Erection of 1 No. two-bedroomed detached bungalow. This application is a Departure from the Development Plan.

Land adjacent to Pindars Lyminster Road Lyminster

Thank you for your internet representation made on 23rd April 2018 which has been recorded as '**an objection**' with the comments as follows:

DRAWING EXISTING SITE PLAN DATE: JANUARY 2018 DRAWN: T. Murray	SCALE 1/500
DRAWING: 18/04/3	REVISION:

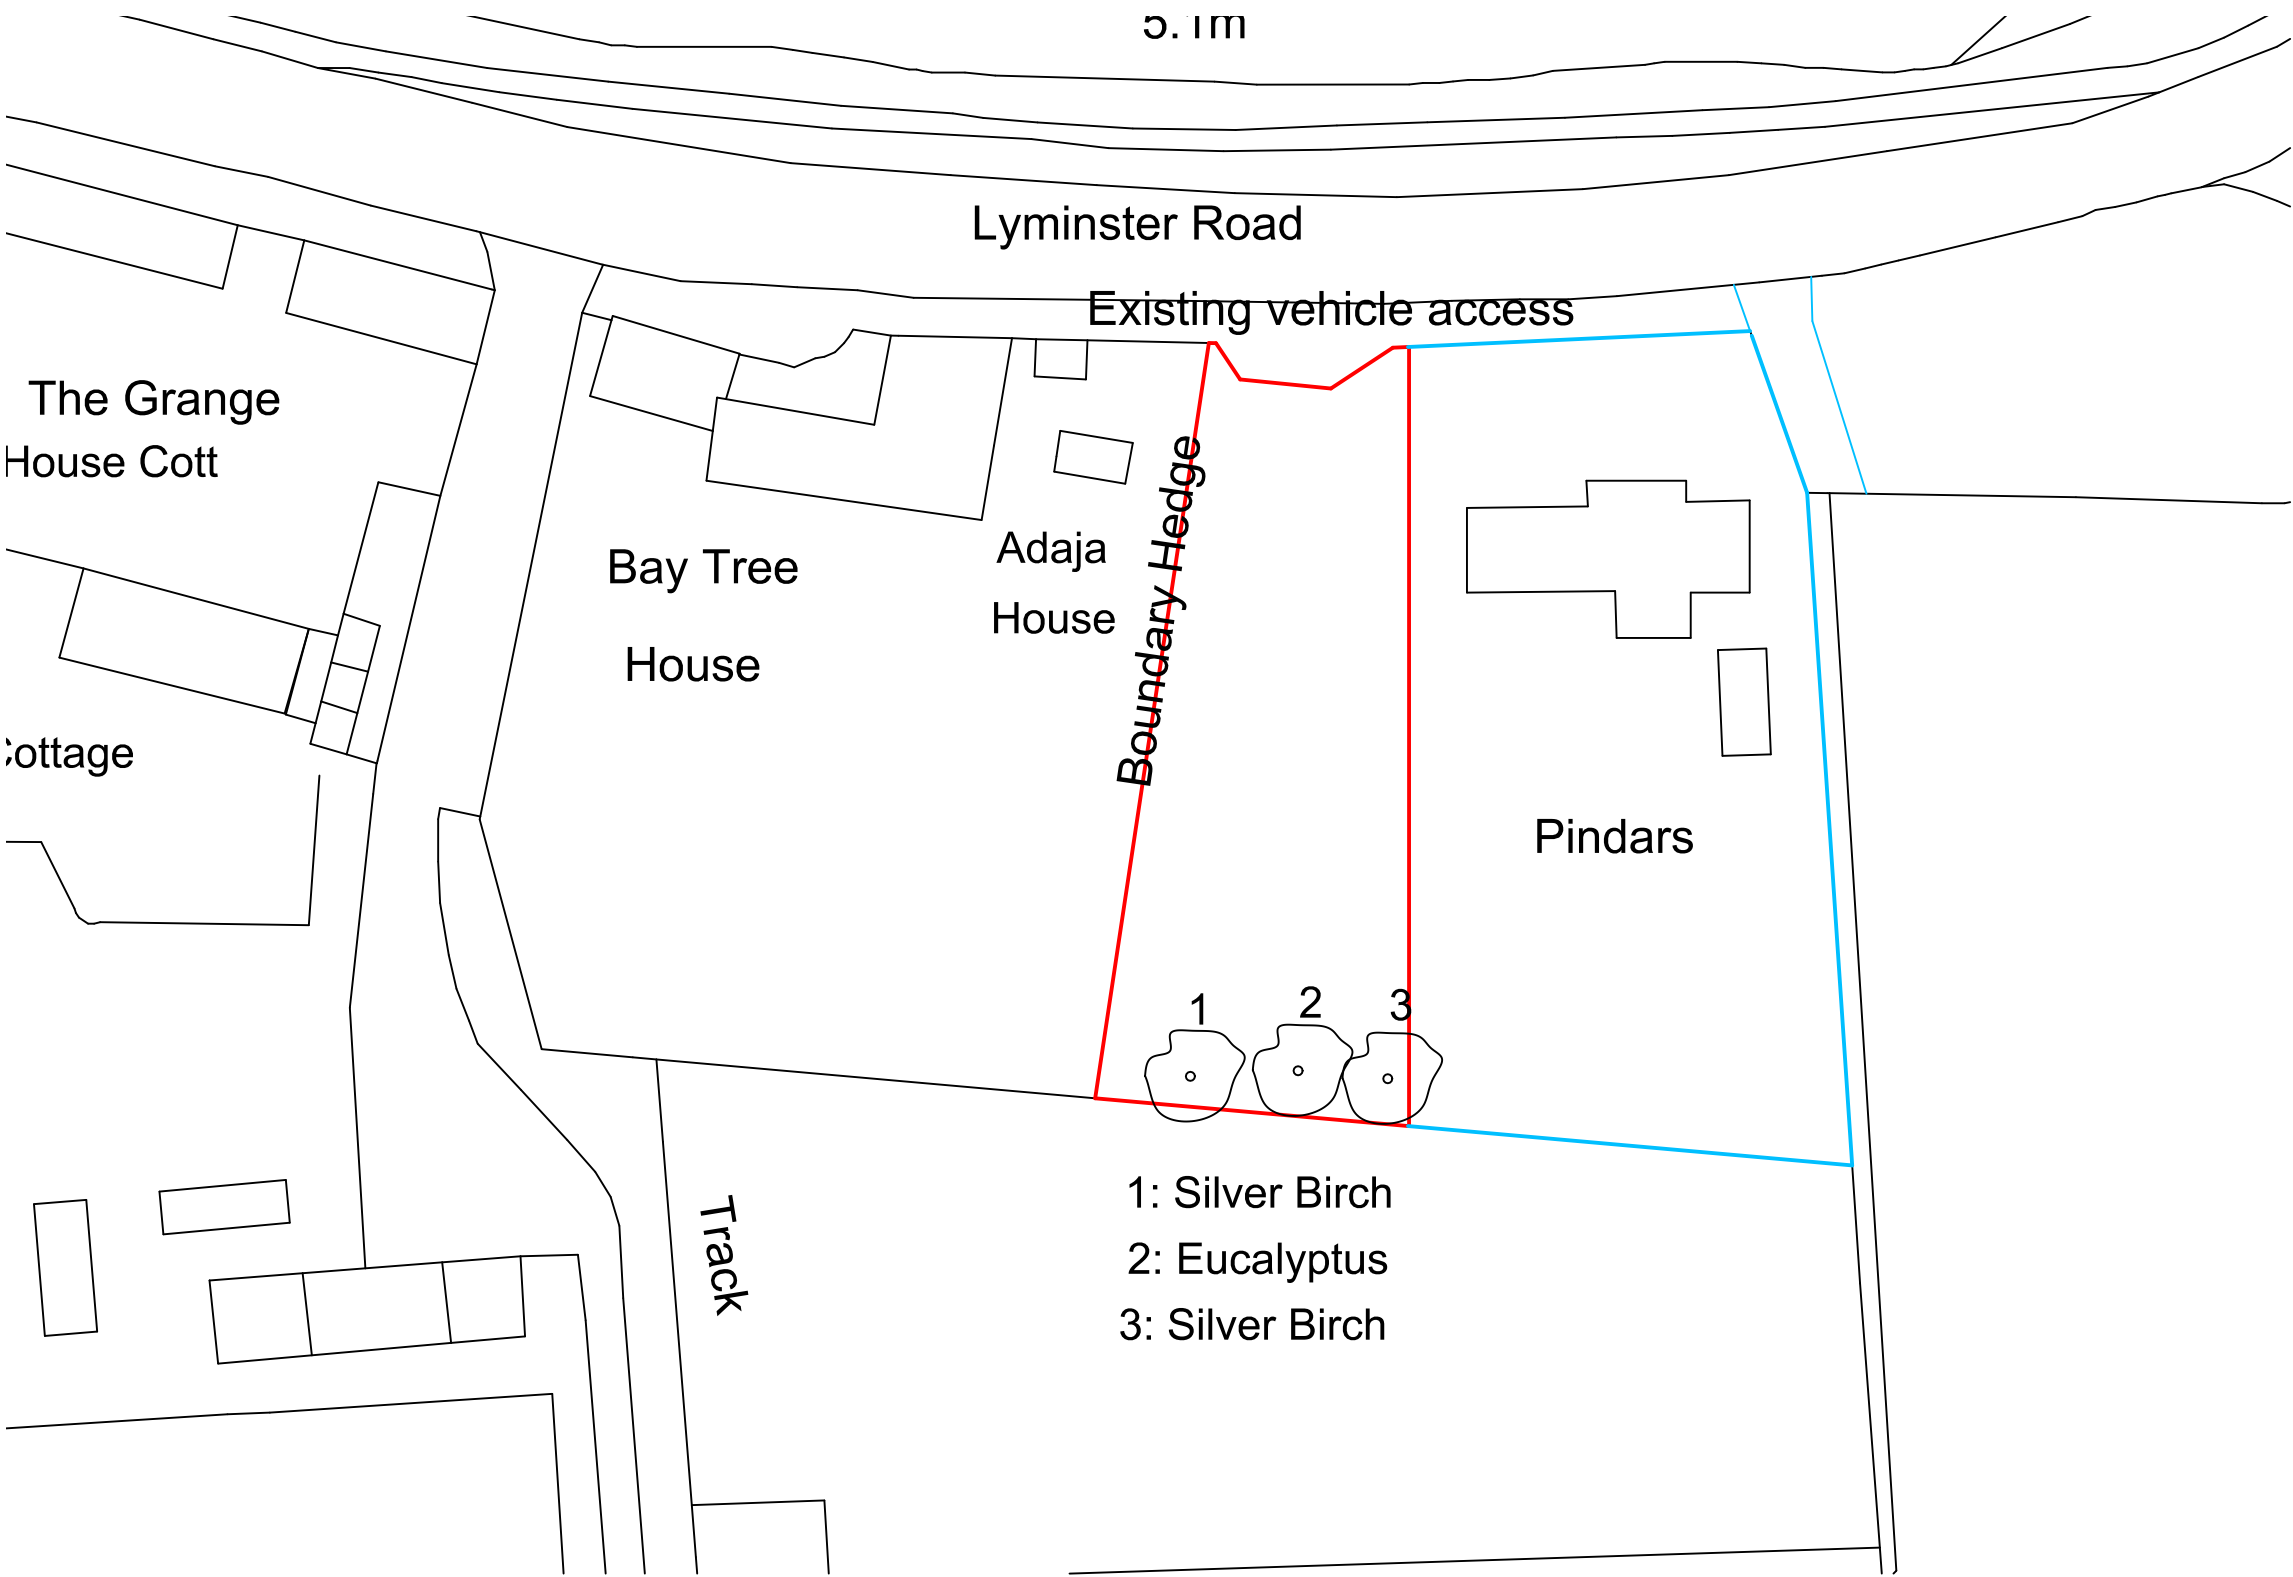
The plan provided with the planning application does not appear to be fully up to date as it does not show the Plindar's approved extension to the ground floor or the location of the large chalet building.

DRAWING PLANNING DATE: JANUARY 2018 DRAWN: T. Murray	SCALE 1/50
DRAWING: 18/04/2	REVISION:

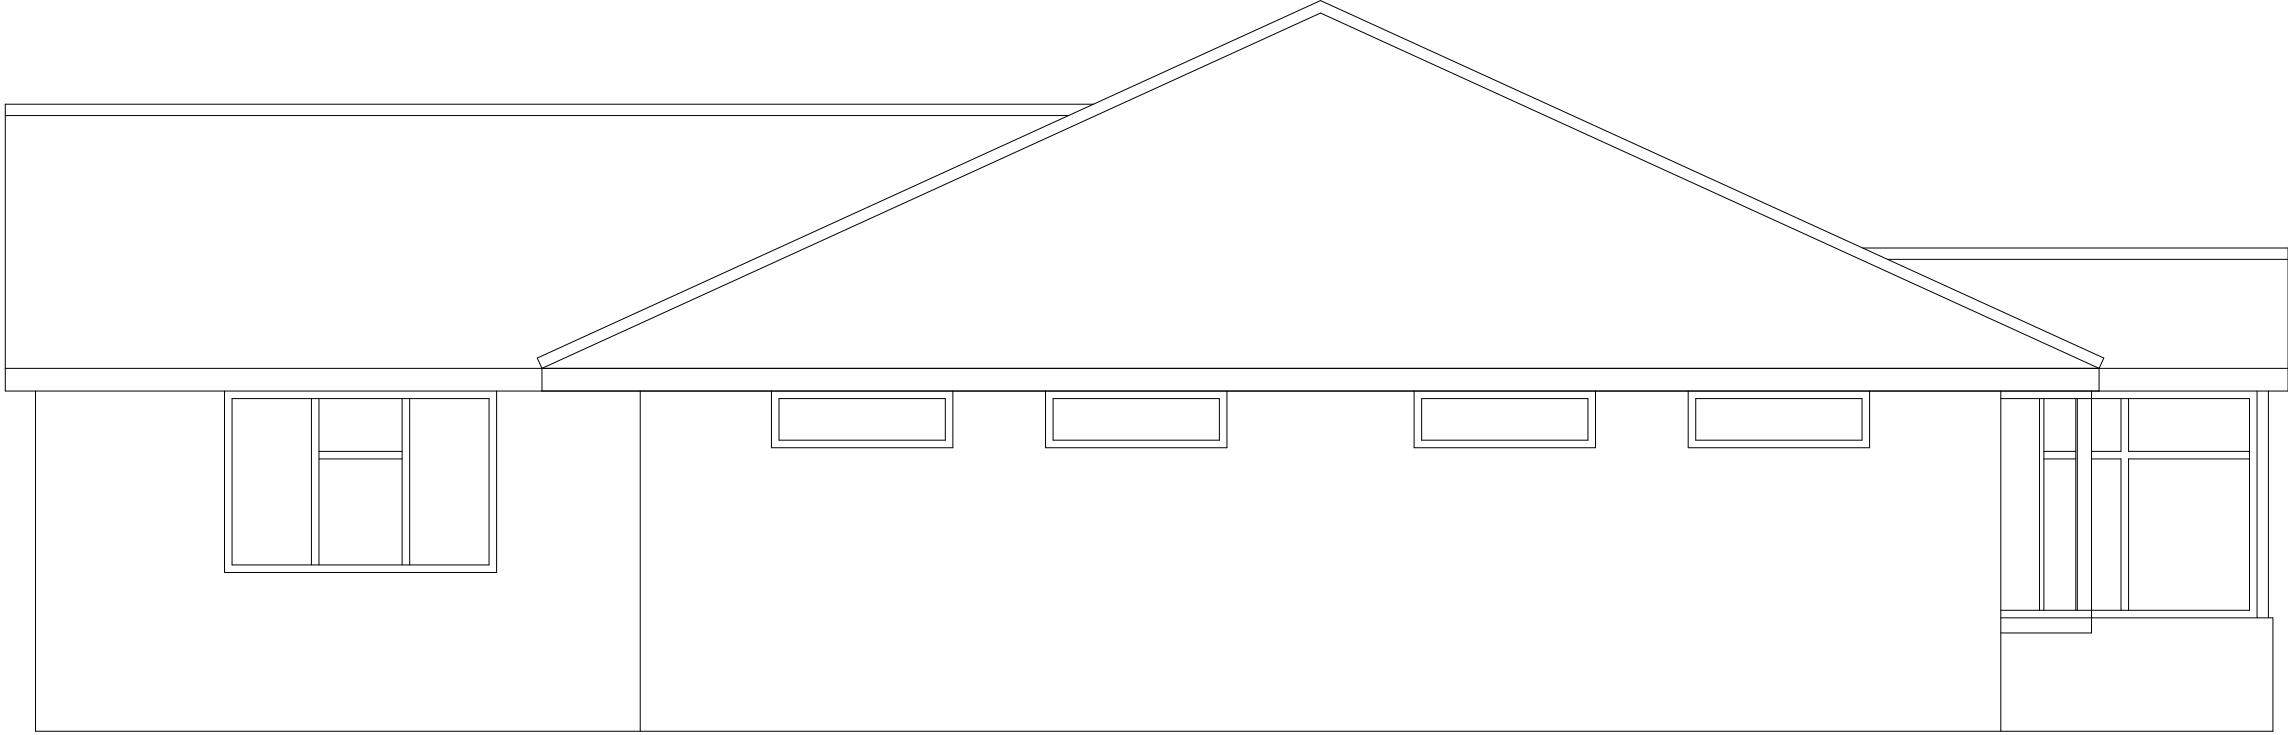
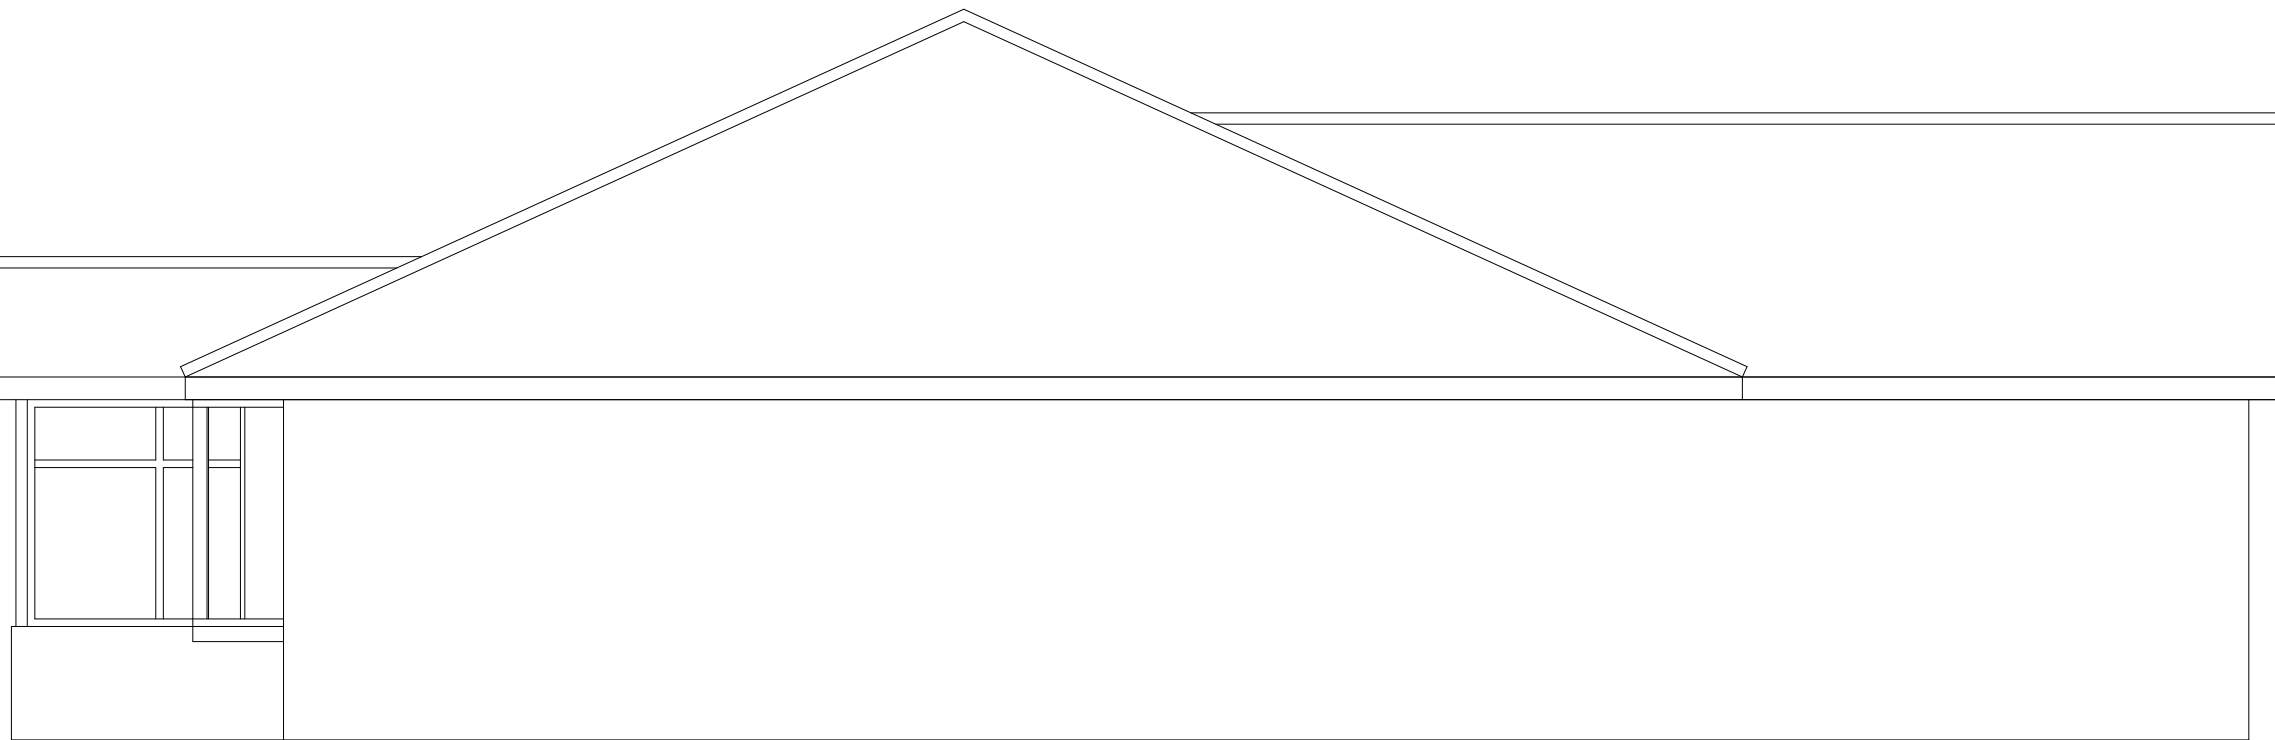
case. Recently a large chalet building was erected parallel to the holly hedge. This building impacts on our garden and the proposed building, which looks significantly higher, will therefore be much more intrusive. The height of the proposed building is not stated but if planning permission is granted we would welcome a maximum height restriction of 4 meters.

DRAWING PROPOSED SITE PLAN DATE: JANUARY 2018 DRAWN: T. Murray	SCALE 1/500
DRAWING: 18/04/4	REVISION:

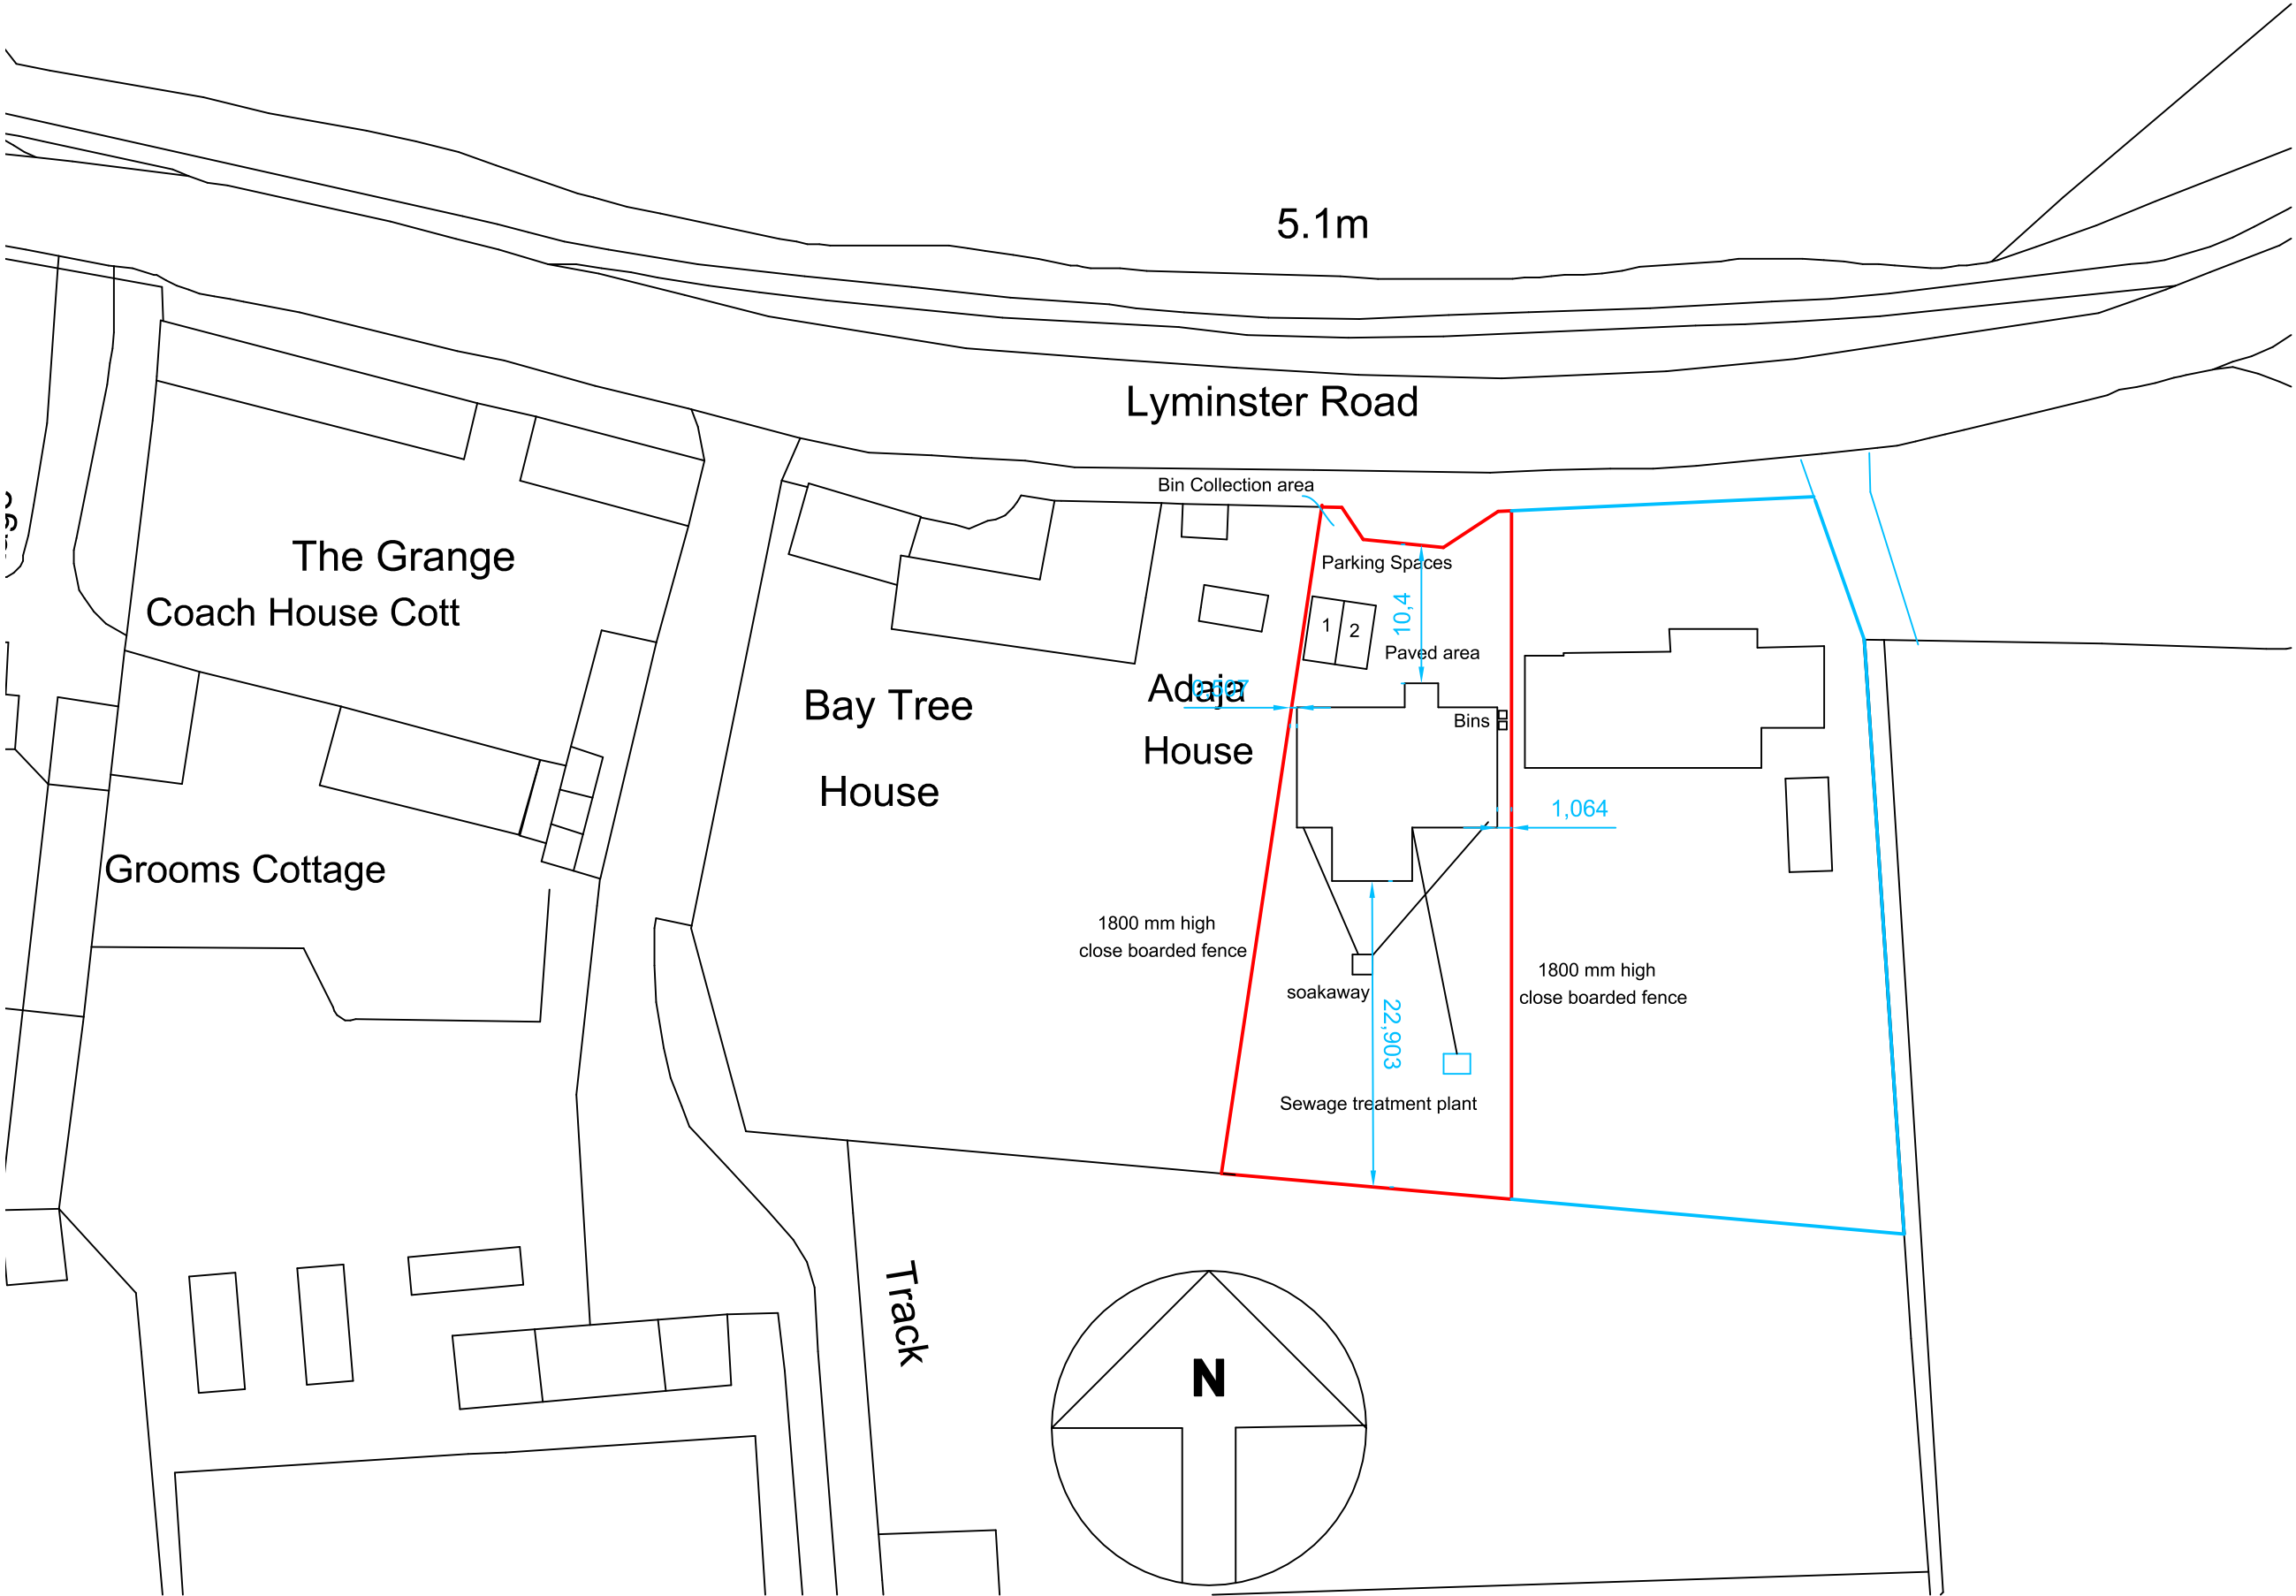
There is one part of the application which refers to the felling of holly trees which are our trees - please see Proposed Site Plan document and Design and Access document. This row of mature holly trees forms a boundary hedge between Bay tree house and PIndars. These trees were planted by the previous owner of Baytree House and have been there for around half a century. This evergreen holly hedge is in keeping with a country garden, it also provides a habitat for wildlife and is hedgehog friendly. For these reasons we would not wish to replace our holly trees with a close boarded fence 1.8 metres high.
